RE: MARRIOT HOTEL AT WINROCK MALL – DRB SUBMITTAL FOR SITE PLAN FOR BUILDING PERMIT

DRB PROJECT NUMBER: PR –2018-001579

Subsequent to comments provided at the DRB Hearing on November 20, 2019 we have the following written responses as well as the accompanying revised documents and drawings. We look forward to reviewing with you at our next scheduled hearing on December 18, 2019.

PROJECT TITLE	WINROCK TOWN CENTER
LOCATION	2100 LOUISIANA BLVD NE
PROJECT MANAGER	STEPHEN DUNBAR, AIA
JOB NO.	WIN-HOTEL
DRAWN BY	XXX
DATE	7/1/21
SCALE	1"=30'
RE: SCALE	SP-1A2
sheet	SP-1A2
of	1

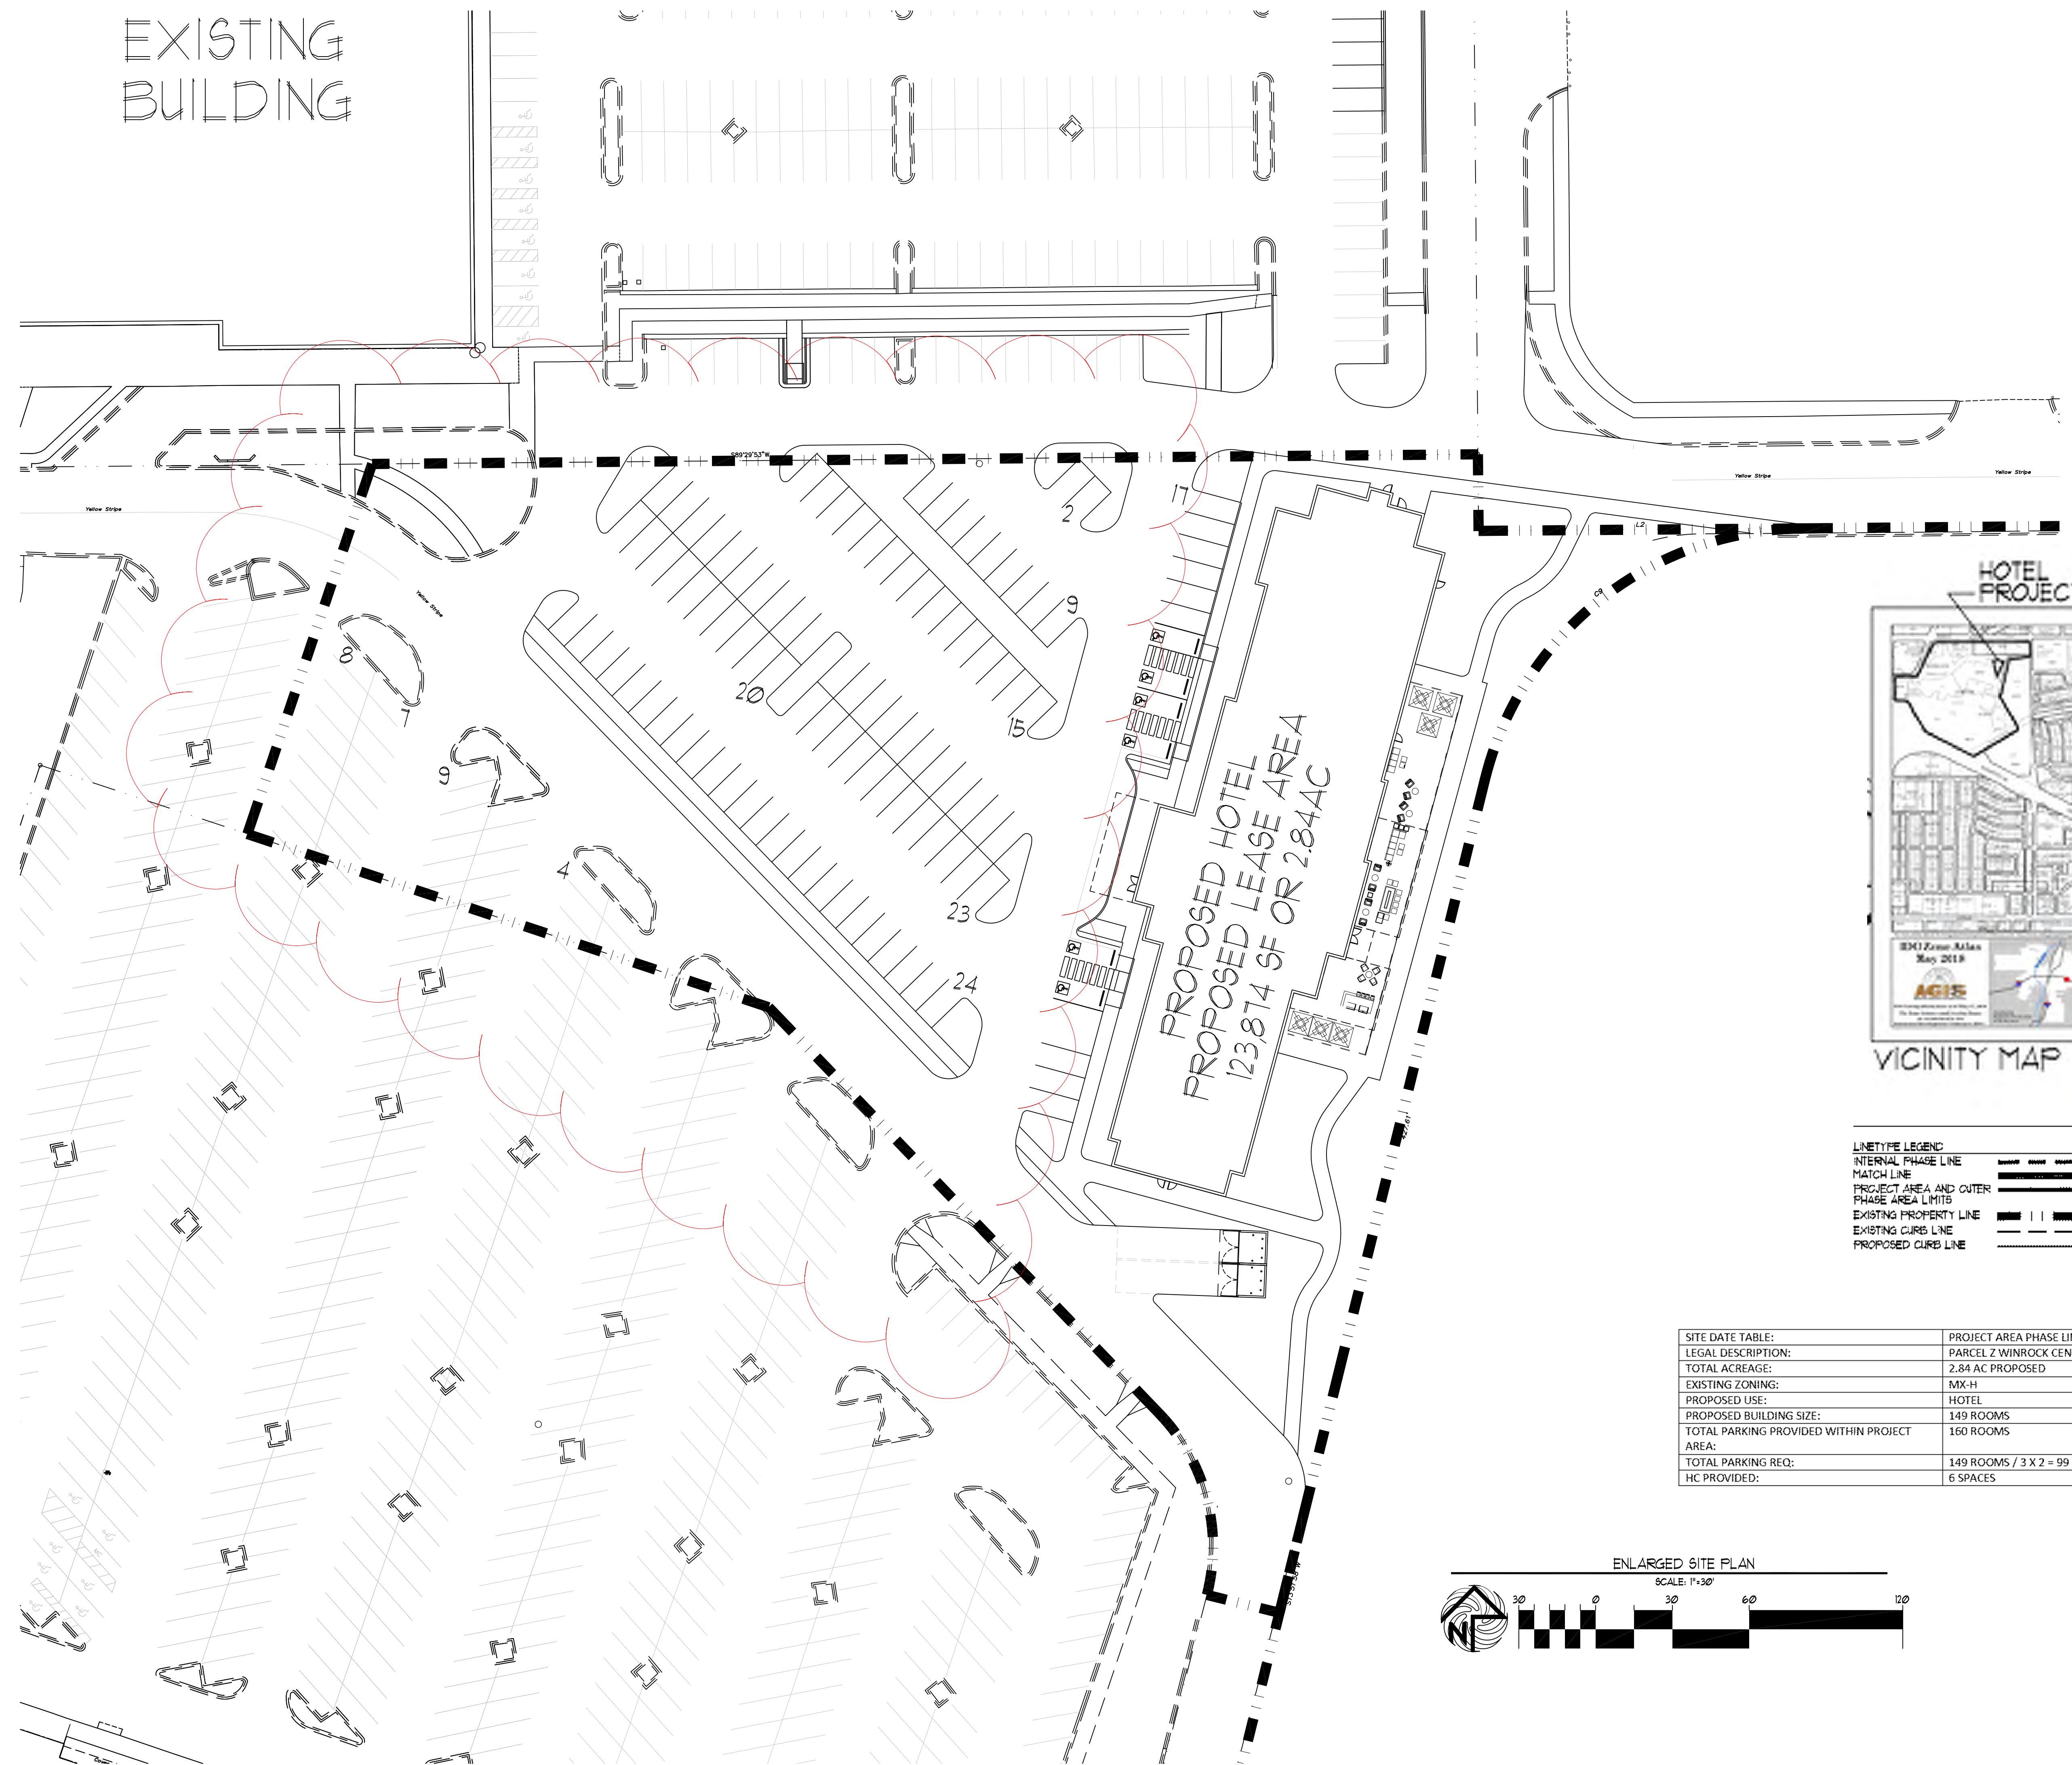
6. Label all on-site concrete walkways, curb and label the asphalt parking lot on the site plan as well as the signs such as the motorcycle parking signs and handicapped space signs.

1. The project number and application number are not listed on Sheet SP-1A2.
 - a. Addressed:
 - i. See Sheet SP-1A2
2. On Sheet SP-1A2, the zoning designation needs to be fixed to MX-H.

- a. Addressed:
 - i. See Sheet SP-1A2: Site Data Table
3. 5-5(E).(1.) of the IDO requires two bicycle spaces + one bicycle space/6,000 square feet GFA of conference, restaurant, bar, and banquet space. In the table on Sheet SP-1A2, it states that ten bicycle spaces are provided and six spaces are required. The applicant does not specify the GFA mixture of the hotel.

- a. Addressed:
 - i. A floor plan has not been proposed the GFA mixture shall not exceed IDO requirements
4. The table on Sheet SP-1A2 states that there are ten handicapped spaces provided, but only six handicapped spaces are depicted on that sheet.

- a. Addressed:
 - i. Sheet SP-1A2: Site Data Table
 - ii.
5. Per 5-8(D).(7.), the maximum height of light poles in a mixed zone district is restricted to 20 feet in height, but the height of the light poles in the plans is 25 feet in height, which is five feet higher than the maximum allowed.

- a. Addressed:
 - i. See Sheet SP-1A2
7. The concrete sidewalk detail should show a maximum 2% cross-slope.
 - a. Addressed:
 - i. See Sheet A1.1 - Site Details: Note 17

- a. Addressed:
 - i. Sheet SP-1A2: Key Note 2
- 6. Make sure that 5-11(E.)(2.) of the IDO regarding façade design is being met.
 - a. Addressed:
 - i. Per the ruling from James Aranda, Deputy Director/Planning Department:

GRADING PLAN FOR DRB SITE PLAN

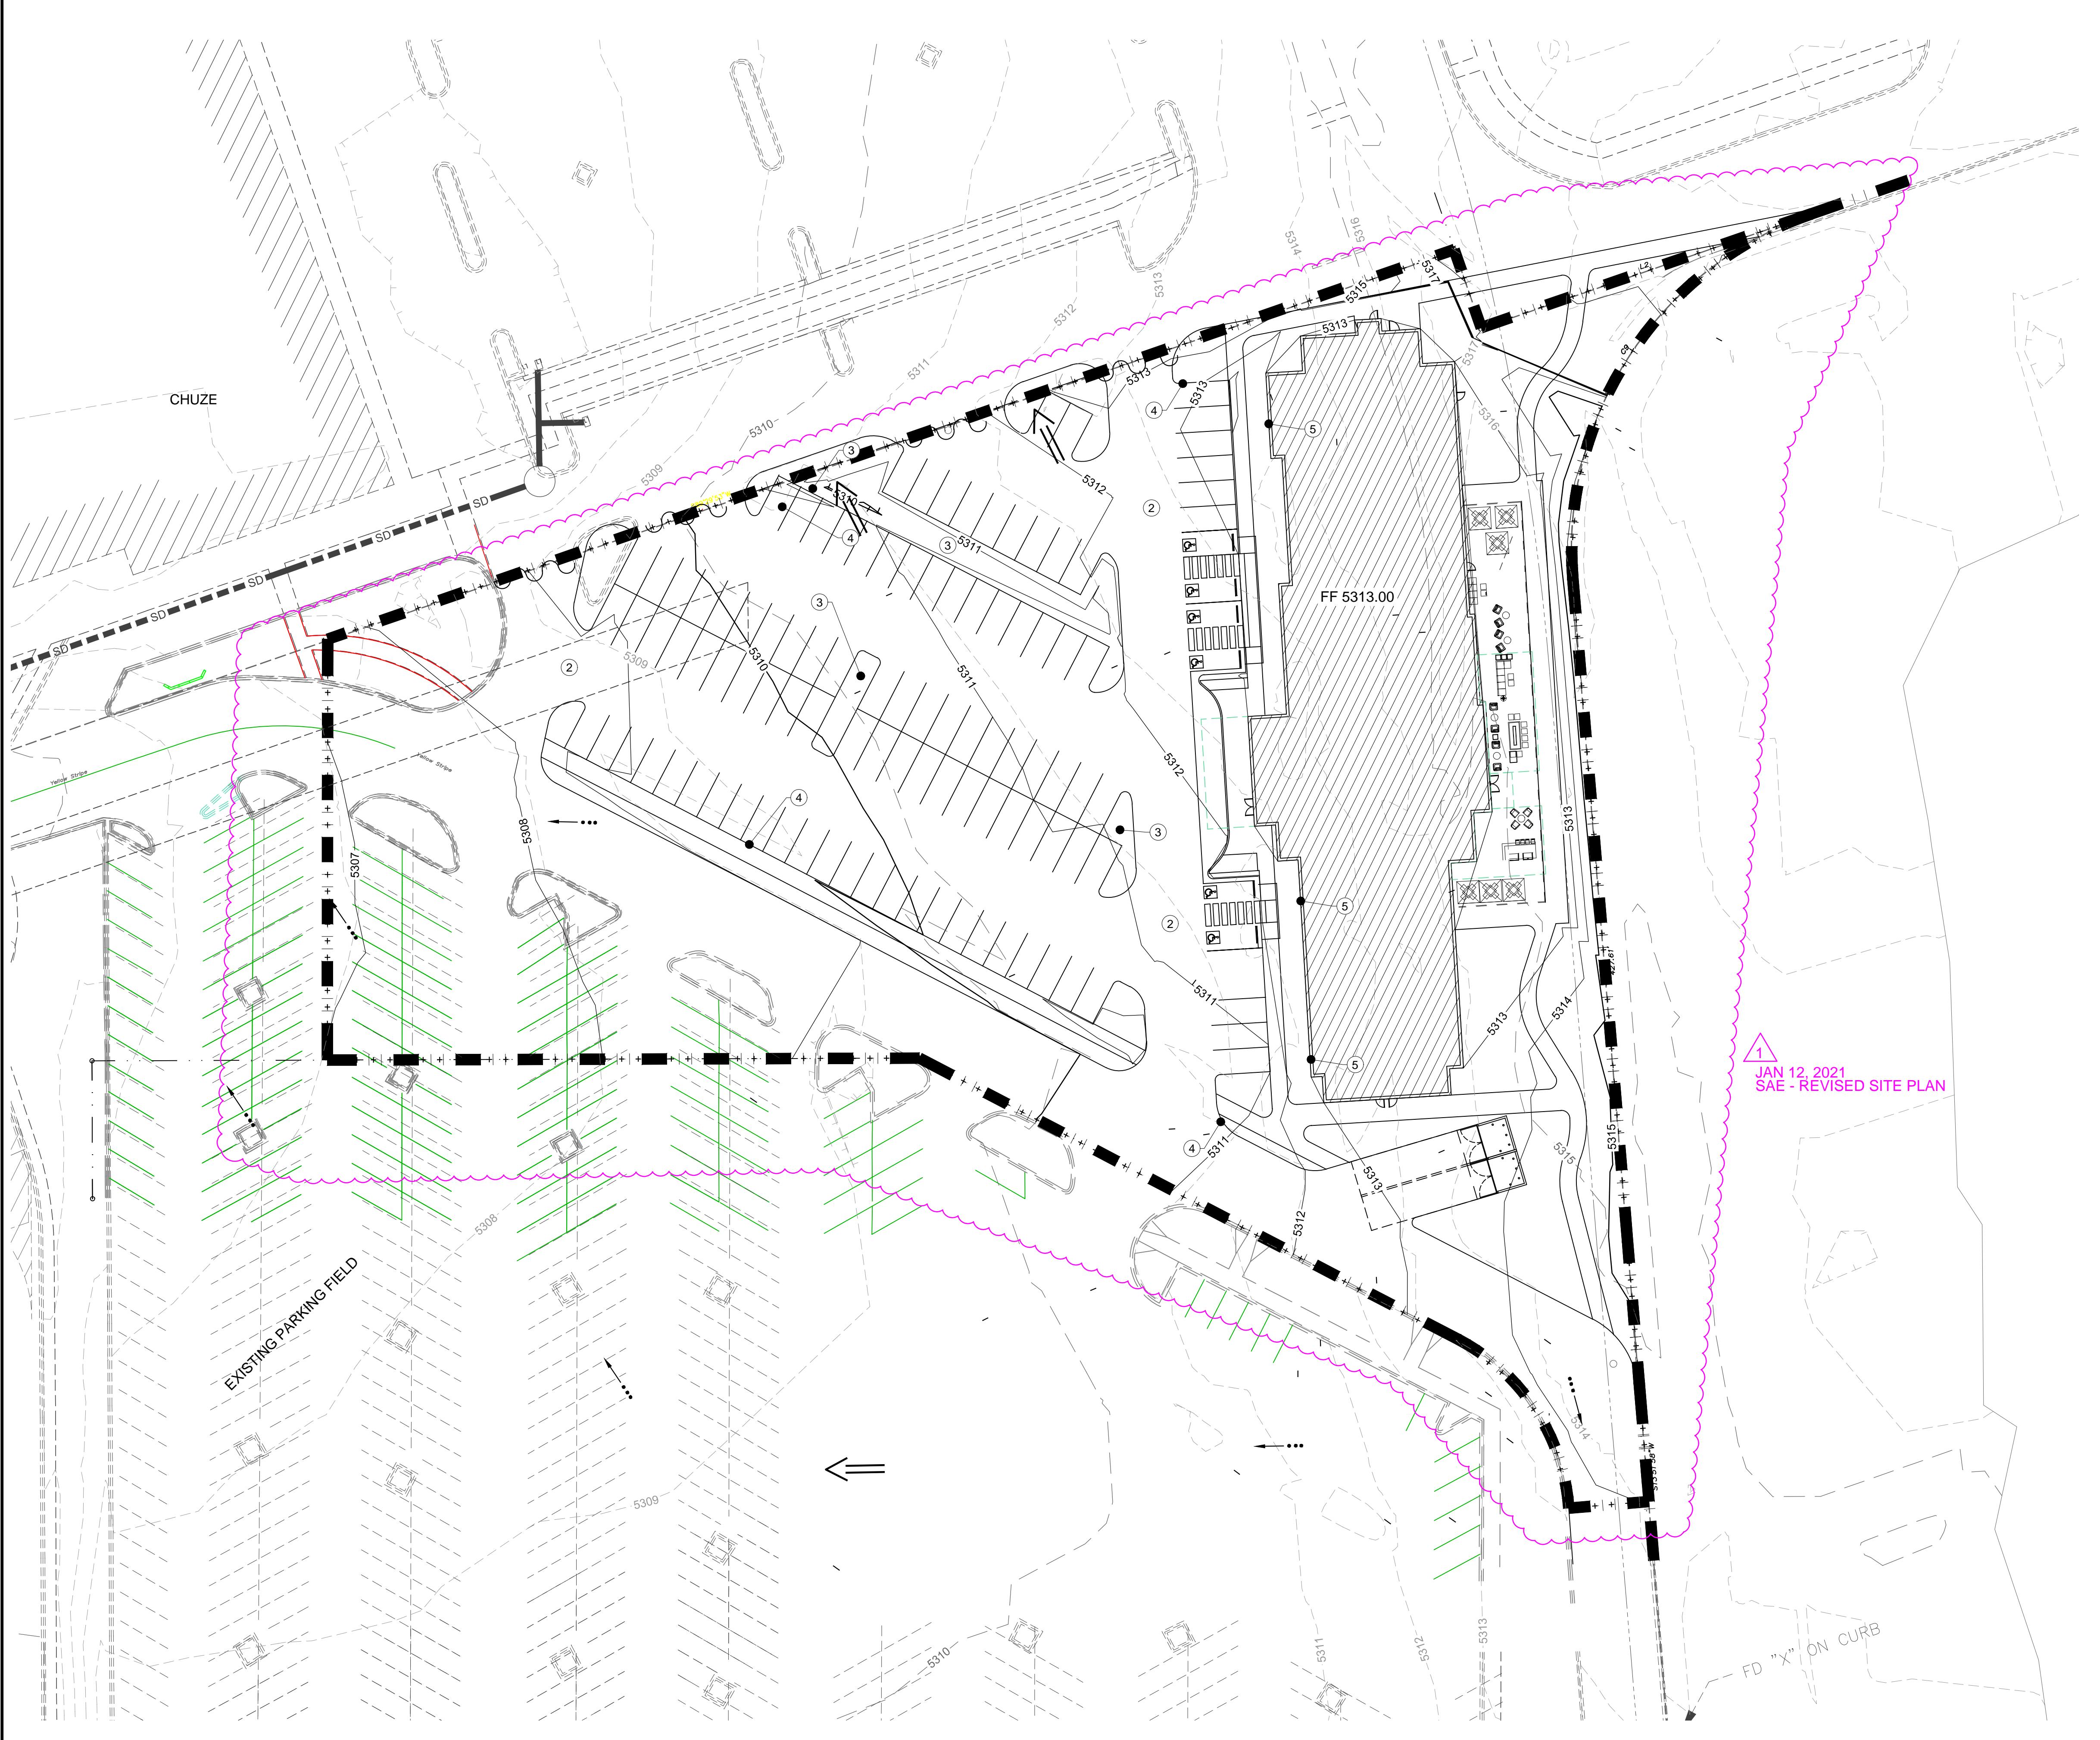
1. An approved Conceptual Grading and Drainage Plan is required.
 - a. Addressed:
 - i. See Sheet C100 – Drainage Plan
 - ii. See Sheet C102 – Grading Plan for DRB Plan

Typical Street Sidewalk
N.T.S.

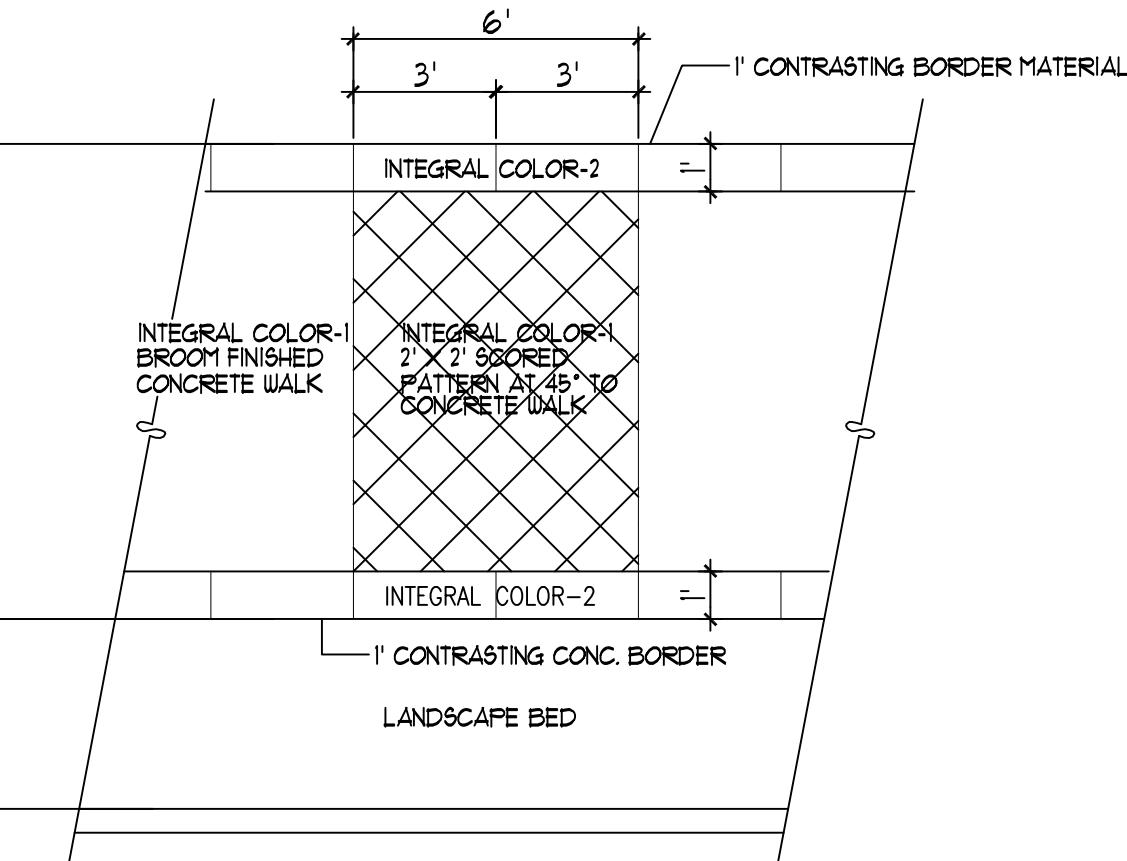
4. The "Typical Street Sidewalk" should be a minimum of 6 inches in thickness, and follow the COA Standard Specifications to support vehicular traffic.

- a. Addressed:
 - i. See A1.1 Site Details: Note 7
5. Provide a street cross-section for the street east of the hotel development with any reconstruction, and provide a copy of the final plat. (Generally, any roads built within public roadway easements or right-of-way dedication to the City of Albuquerque require a work order.)
